## 1-5 Park St (Chequers): 6/2018/2497/FULL and 6/2018/2498/LB Further Submission by Old Hatfield Residents Association

Chairman, Old Hatfield Residents Association  
26 February 2019

Proposed ground floor plan

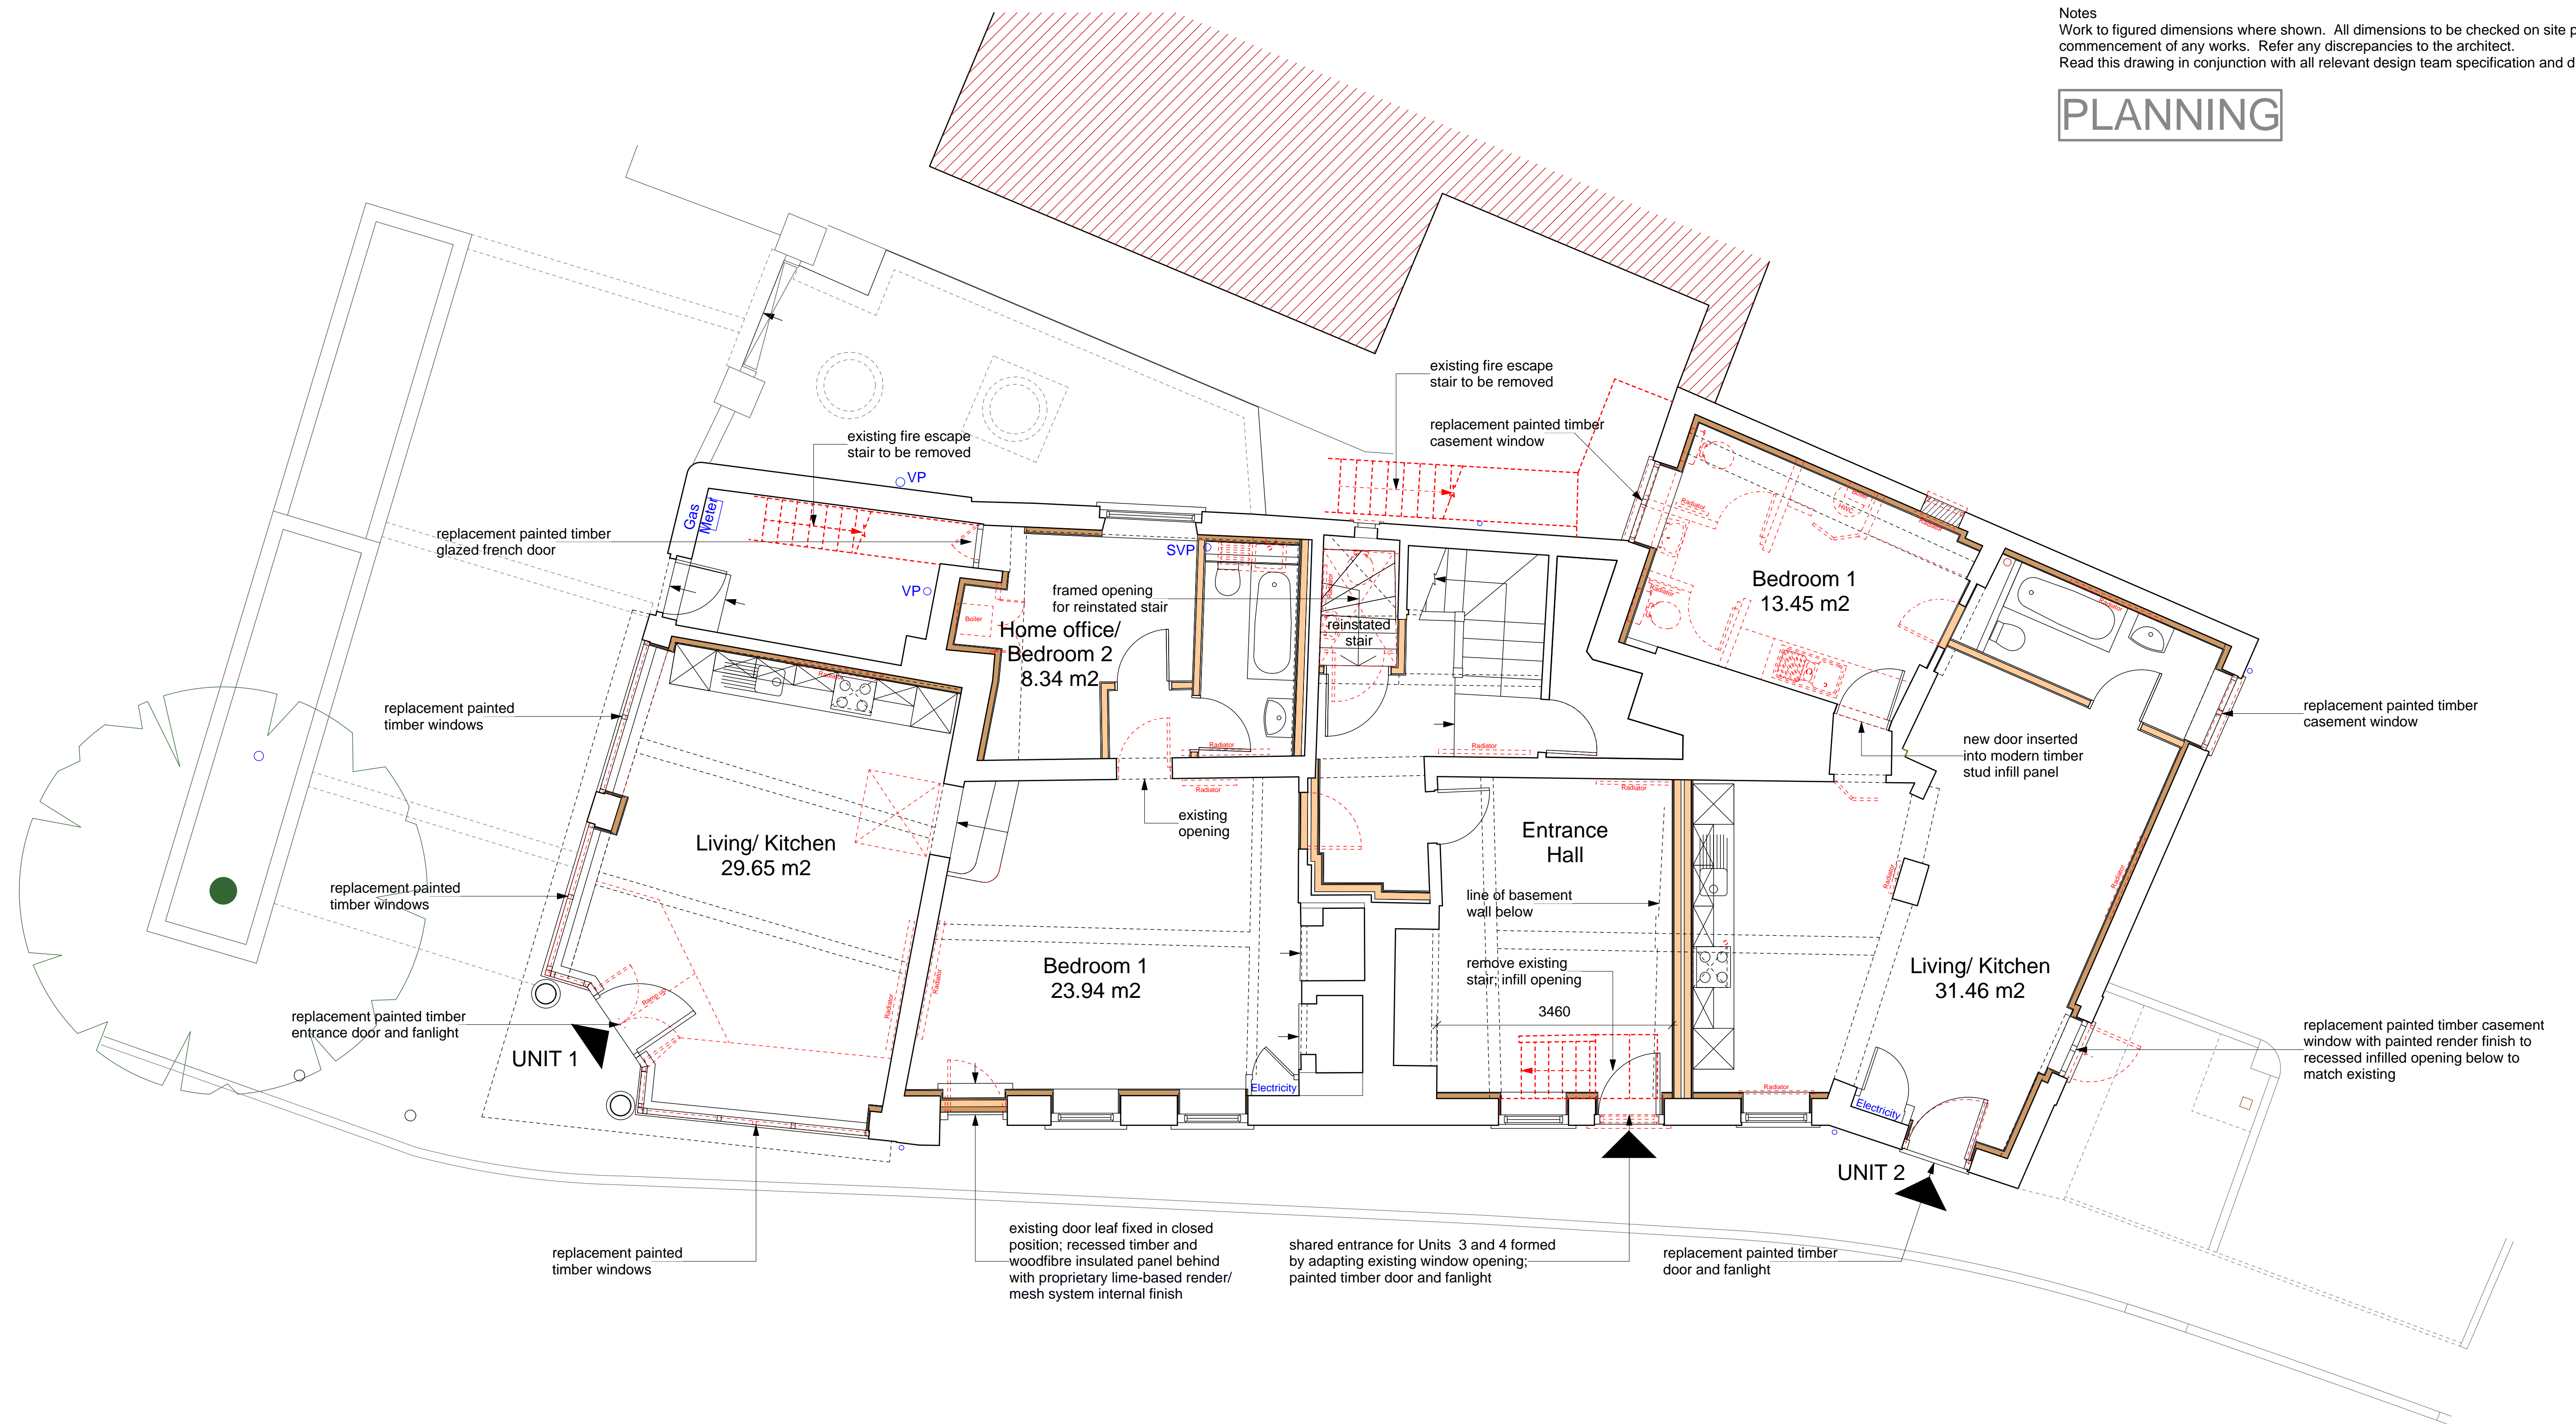
2. The internal conversions for the 4 flat option are likely to be more problematic than those of the house or house + 2 flat options, which could be more closely linked to the existing internal lay out. But the internal plans are vague on all this. We are furthermore concerned that the tensions between protecting the historic fabric and providing flats that comply with building regulations, will make it difficult to complete the project and are likely to further increase the costings in a way that a different configuration could have avoided.
